Recommendation Report for Planning Permission for Works or Extension to a Dwelling

REF NO: P/63/19/HH

LOCATION: 10 Bridorley Close
Pagham
PO21 3NP

PROPOSAL: Proposed Loft Conversion (comprising front facing roof-lights, side gable window, and rear facing dormer / windows). Proposed single storey side and rear extension.

CLIENT	Mr E Morgan	DRAWING	001 Existing & Proposed Floor Plans		
SITE	10 Bridorley Close, Pagham	DATE	03 07 19	AUTHOR	AH
PROJECT	Proposed Extensions & Alterations	SCALE	1: 100 @ A3	STATUS	PL

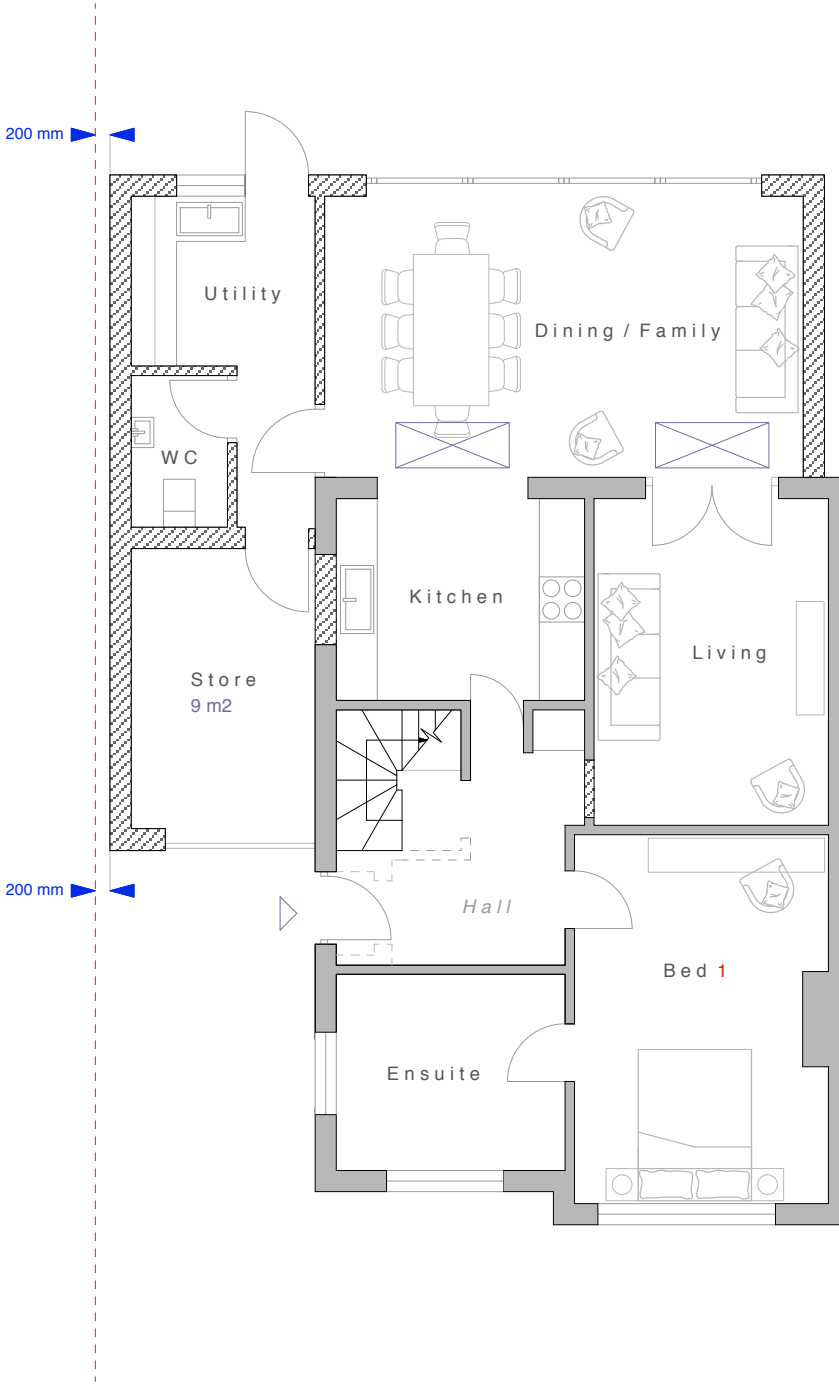
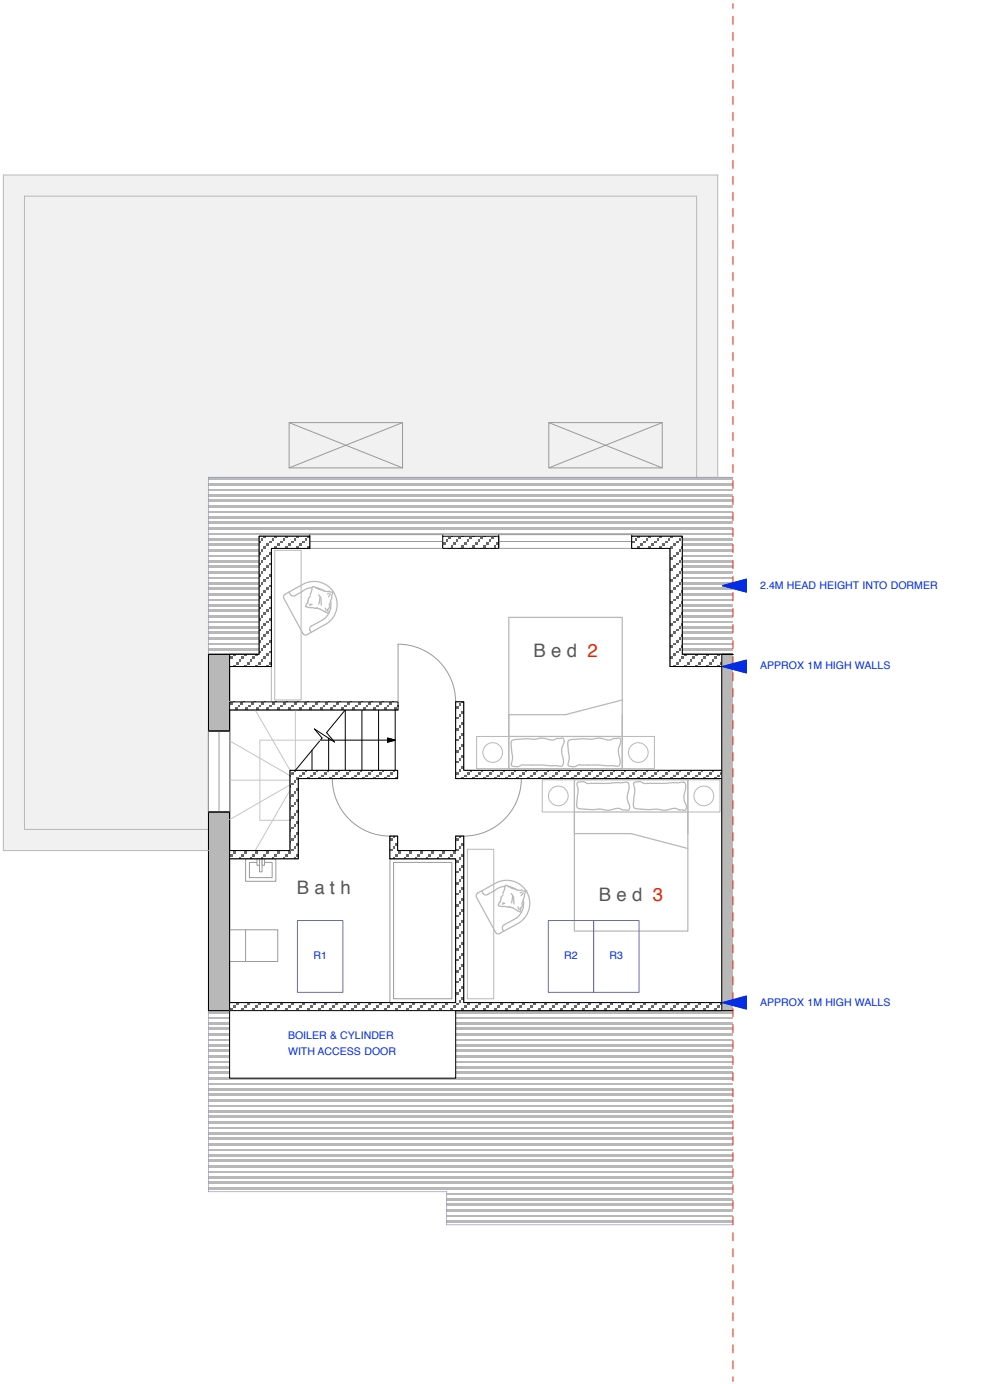
The proposed extension will remove the existing conservatory and replace with a rear extension which wraps around the side to create an L shaped extension. The rear extension sits around 0.25m further in depth than the existing at 4m and will have a flat roof to a height of 3.1m.

The extension will run along the full rear elevation however the property at No.12 has an extension also and therefore is not considered to result in adverse impacts. The property at No.8 also has a garage that runs along the boundary towards the rear of the property and therefore again the side extension is not considered to result in overbearing or overshadowing impacts.

CLIENT	Mr E Morgan	DRAWING	002 Existing & Proposed Elevations		
SITE	10 Bridorley Close, Pagham	DATE	03 07 19	AUTHOR	AH
PROJECT	Proposed Extensions & Alterations	SCALE	1: 100 @ A3	STATUS	PL

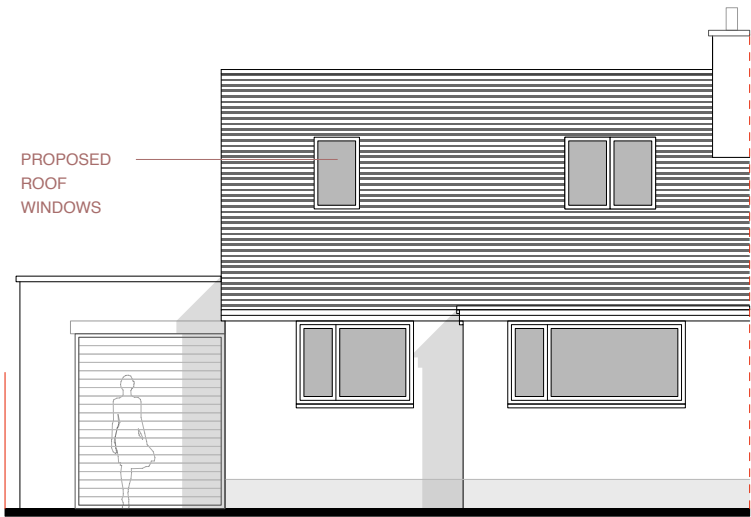
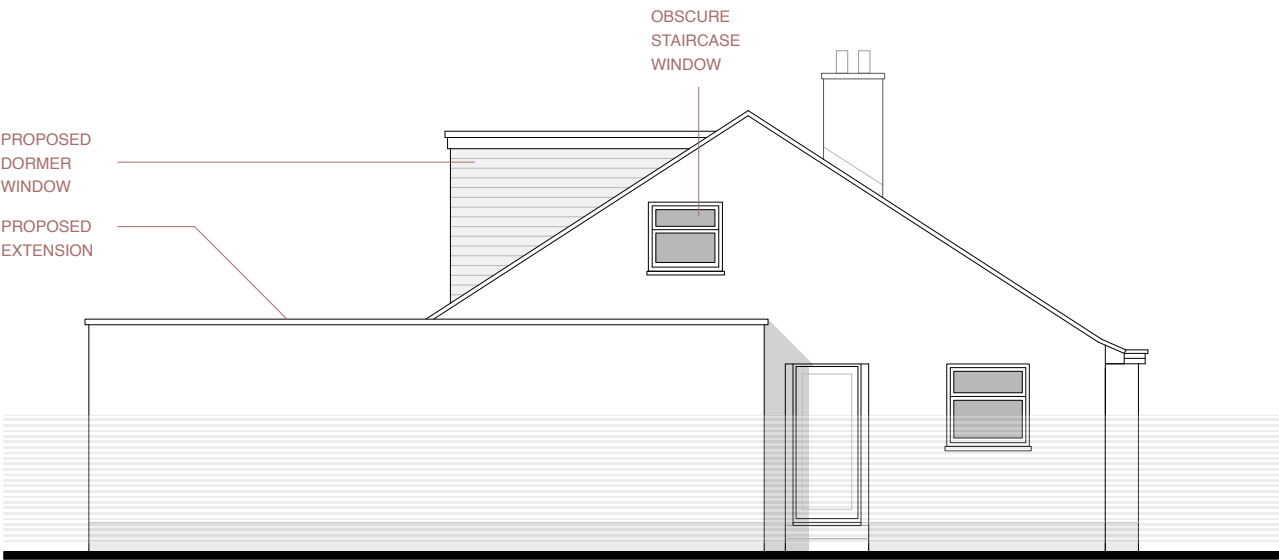
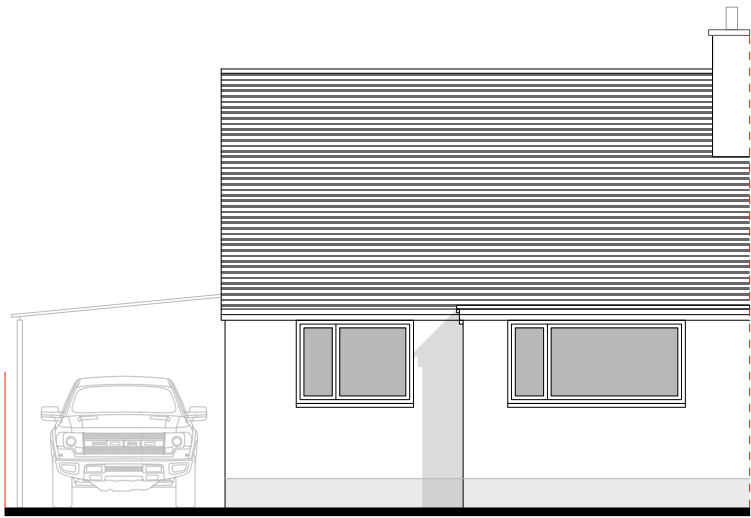
There is an existing car port which will be removed. The side extension will sit around 4m behind the principal elevation of the dwelling and will have a height of 3.1m and a width of 2.7m. Due to it being set back from the street scene and its modest height it does not appear unduly dominant. The side addition is also not considered out of character with garages visible to the side elevations at surrounding properties.

The dormer to the rear is proposed to have grey weatherboarding however this will not be visible from the street scene and is considered acceptable.

A dormer is also proposed to the rear elevation. This will have a depth of 3.45m and a height of 2.2m. The property to the west also has a rear dormer. This is not considered to result in adverse overlooking with no direct views into neighbouring properties.

CLIENT	Mr E Morgan	DRAWING	004 Existing & Proposed Elevations		
SITE	10 Bridorley Close, Pagham	DATE	12 07 19	AUTHOR	AH
PROJECT	Proposed Extensions & Alterations	SCALE	1: 100 @ A3	STATUS	PL

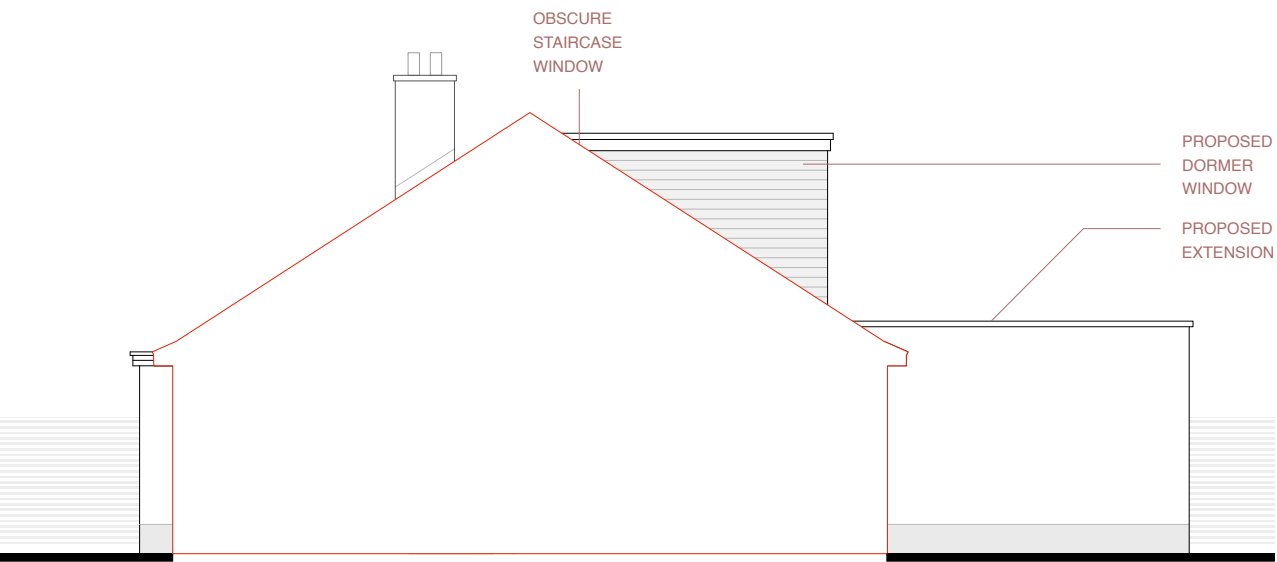
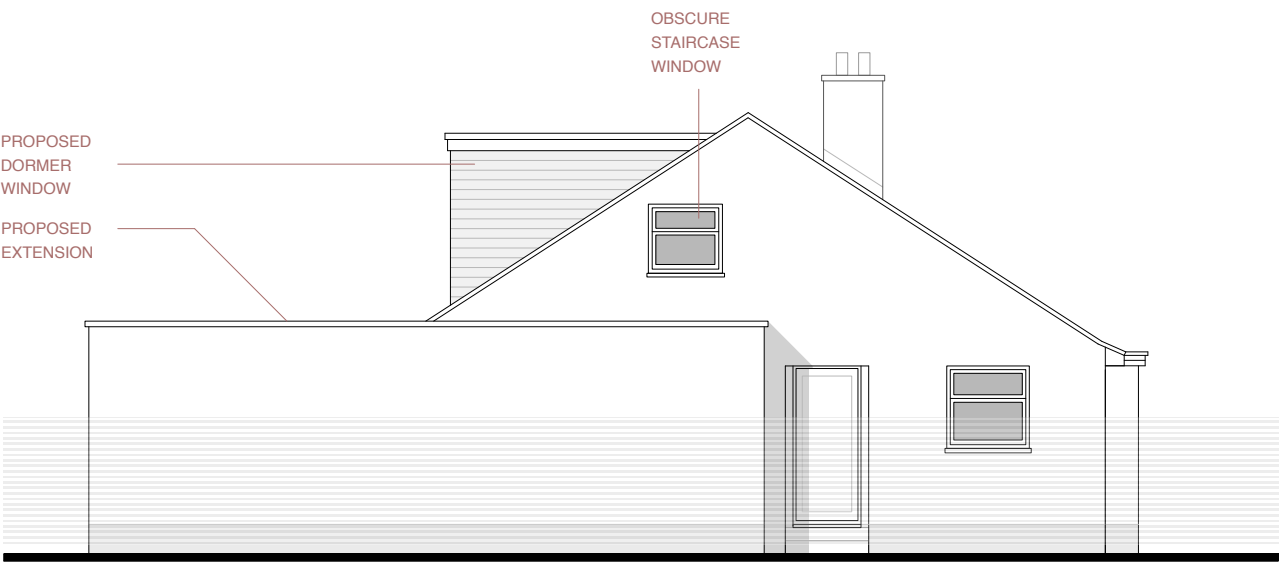
An obscured window is proposed to the side elevation which will be conditioned to ensure there is no adverse overlooking. Additional doors to the rear will be at single storey level and views are not considered to increase from that which is possible.

Reason: To comply with Section 91 of the Town and Country Planning Act 1990 (as amended).
- 2 The development hereby approved shall be carried out in accordance with the following approved plans
 - Location and Site Plan
 - Side Elevations - 004
 - Elevations - 002
 - Floor Plans - 001
Reason: For the avoidance of doubt and in the interests of amenity and the environment in accordance with policy DDM1 of the Arun Local Plan.
- 3 The window on the south east elevation of the building shall at all times be glazed with obscured glass and only openable at a high level, at least 1.7m above finished floor level.
